6th January 2014

Application for Householder Planning Permission

Development Garden shed with log store
Location 1 Abercorn Walk Old Rectory Drive Eastergate

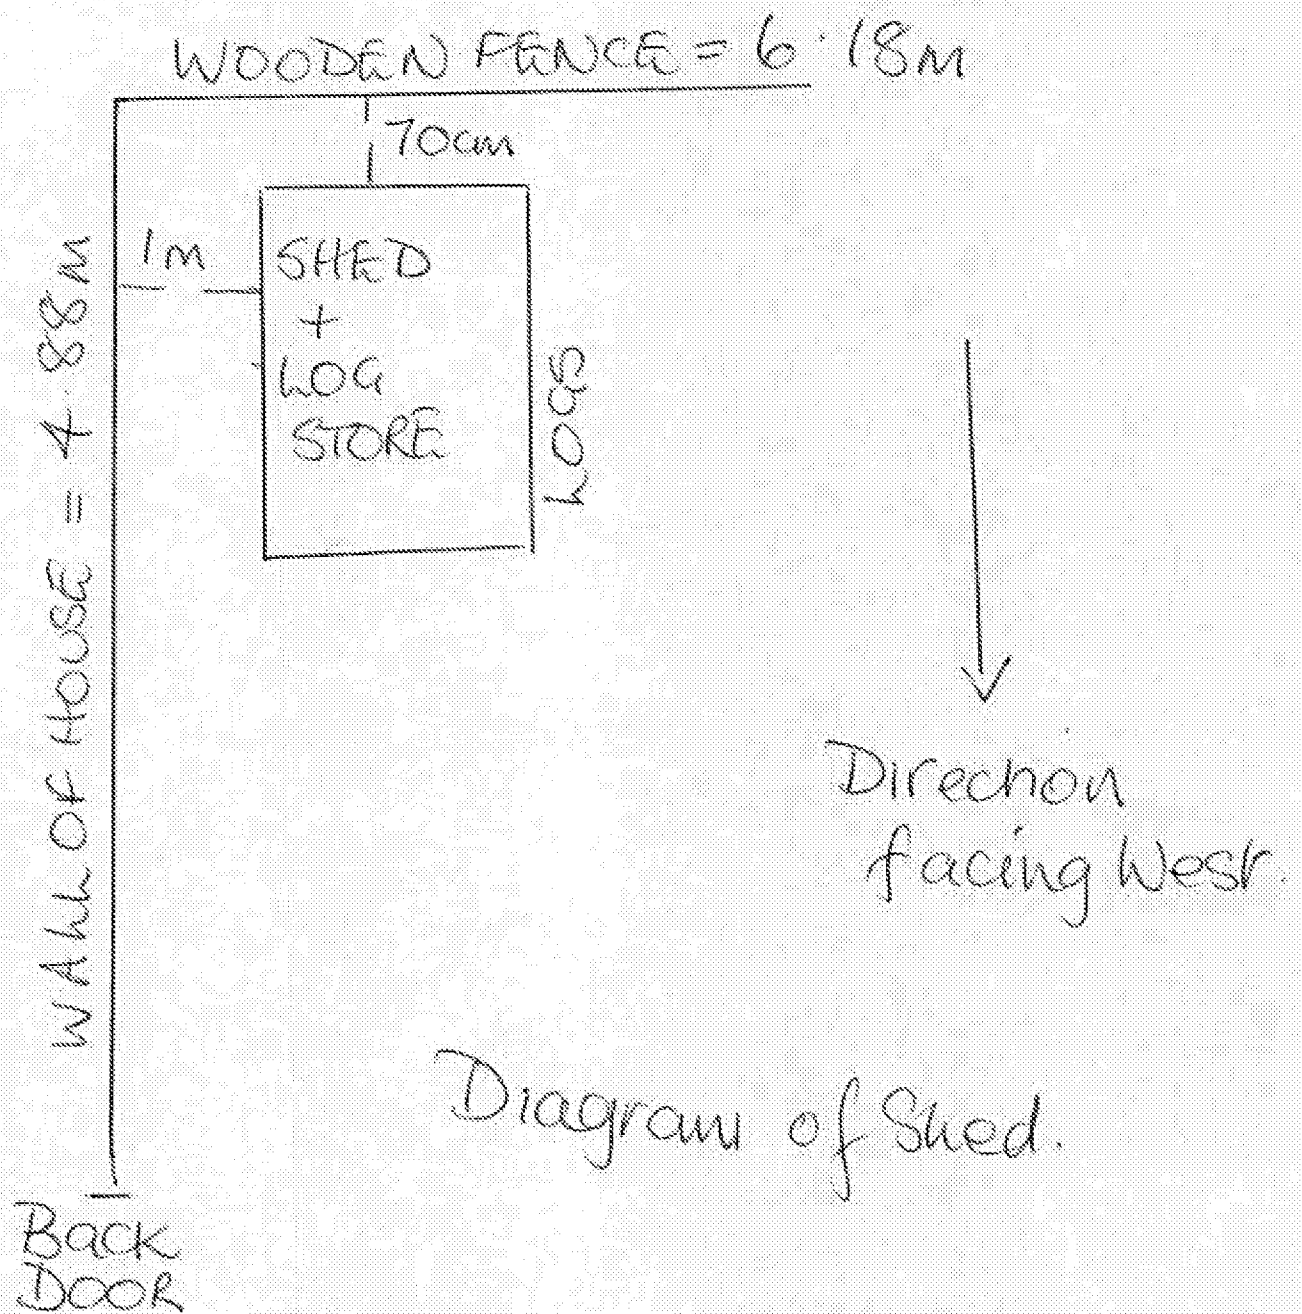
The floor plan is unclear. You only need to provide the shed and log store footprint. The walls laid flat are not required (I'm assuming that's what is shown on the current plans provided)
